ENVIRONMENT AGENCY

WRITTEN REPRESENTATIONS

HIGHWAYS ENGLAND RESPONSE

Development Consent Order Application M4 - Junctions 3-12 (Smart Motorway)

PLAN
SCALE 1:200

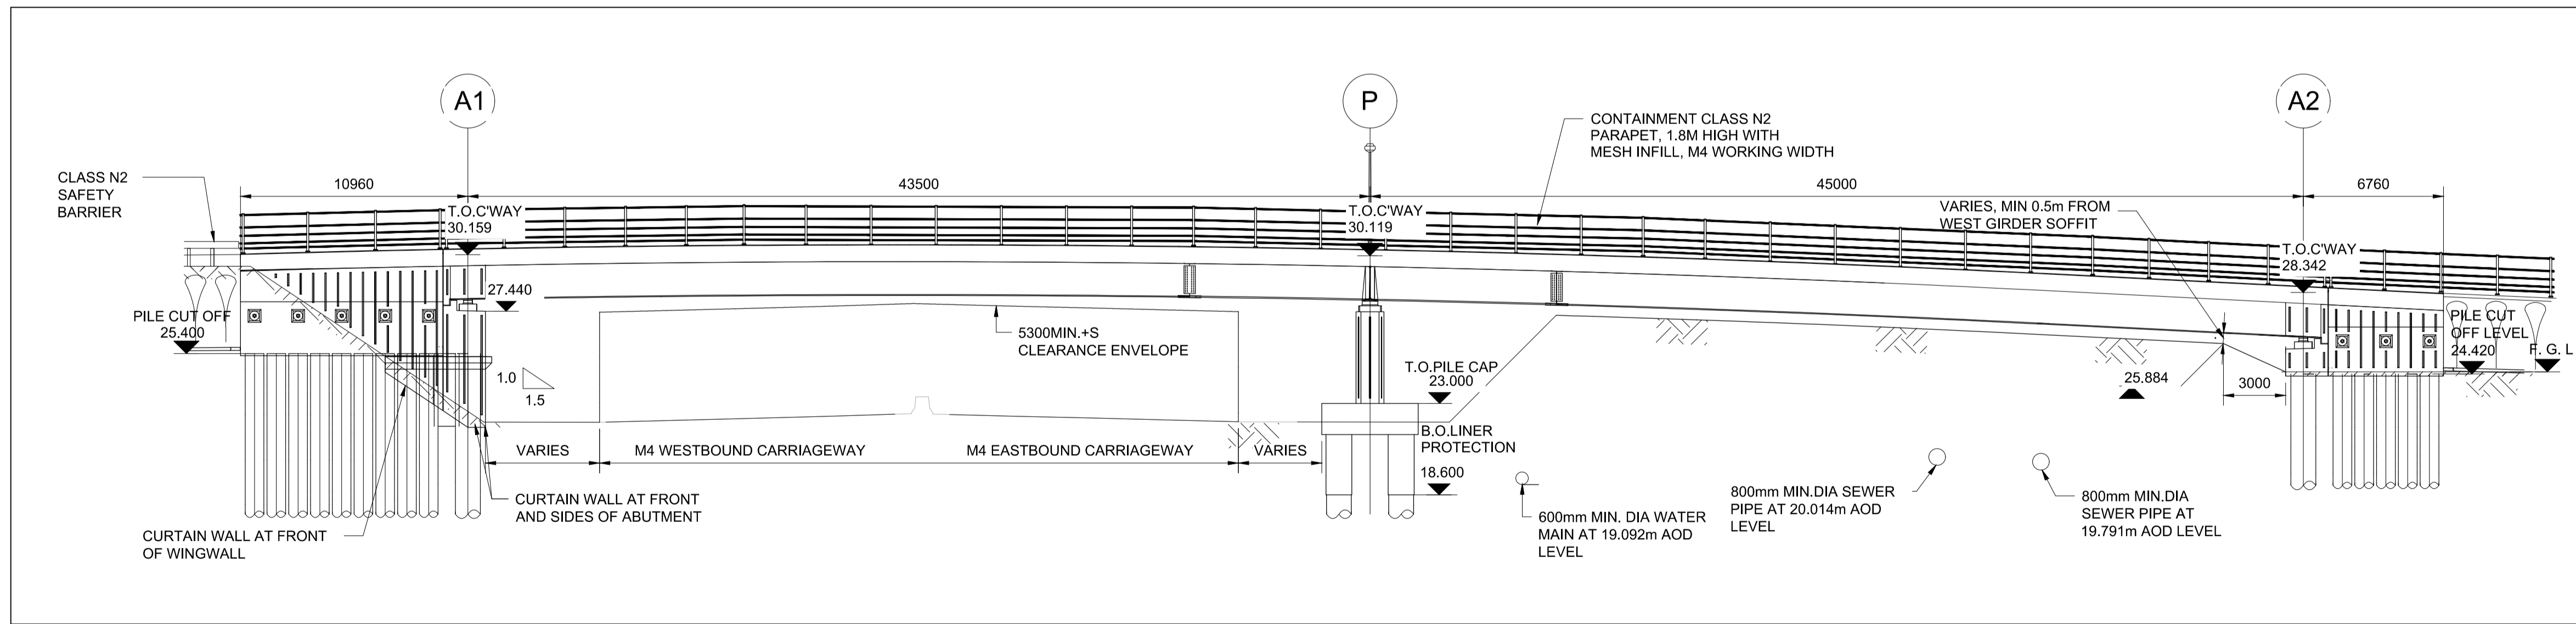
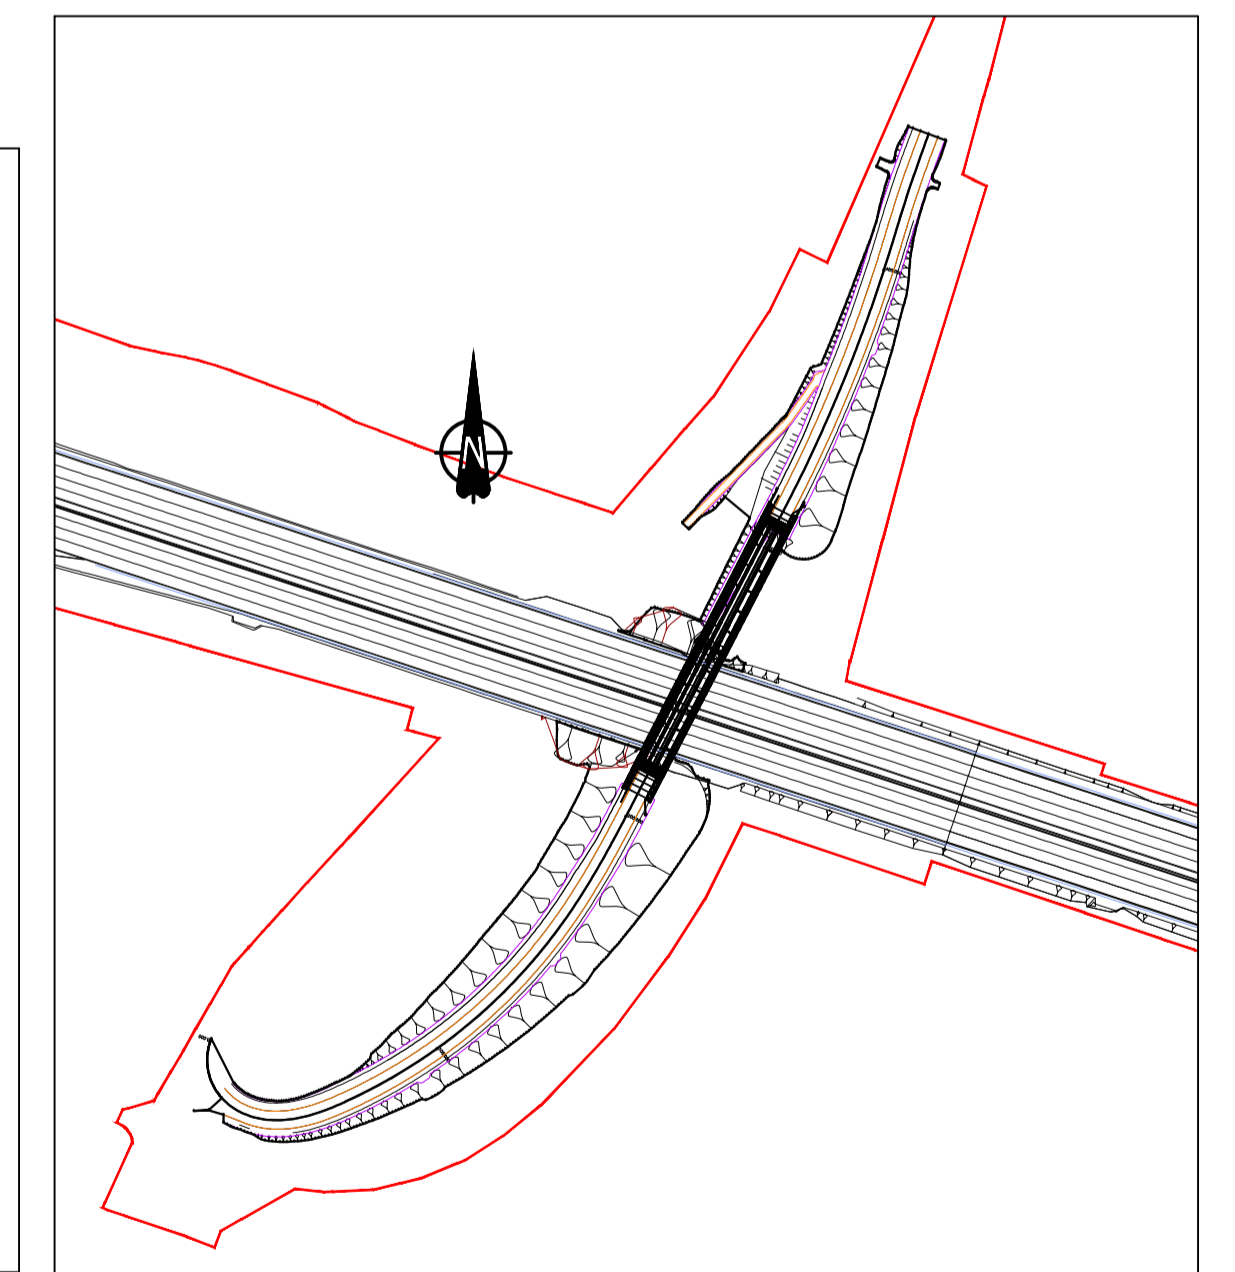
<i>Issue Ref</i>	<i>Issue</i>	<i>How Addressed</i>	<i>Highways England's Comments</i>
	1.8	<i>Junctions 7 - 6 Side road - Wood Lane. The FRA does not demonstrate that compensation can be achieved on a level for level basis.</i>	<i>Awaiting further information/details on FpC from HE.</i>	The updated FRA (paragraphs 5.1.37 and 5.1.38) at Appendix A has quantified that the proposed works at Wood Lane result in a floodplain storage loss of 150m ³ and that compensation for this loss on a volumetric equivalent basis can be provided. A level for level compensation solution will be further explored during the detailed design stage of the Scheme and will be provided where it can be achieved within the Order Limits and with no worse environmental affects, subject to approval by the Secretary of State and the Environment Agency.
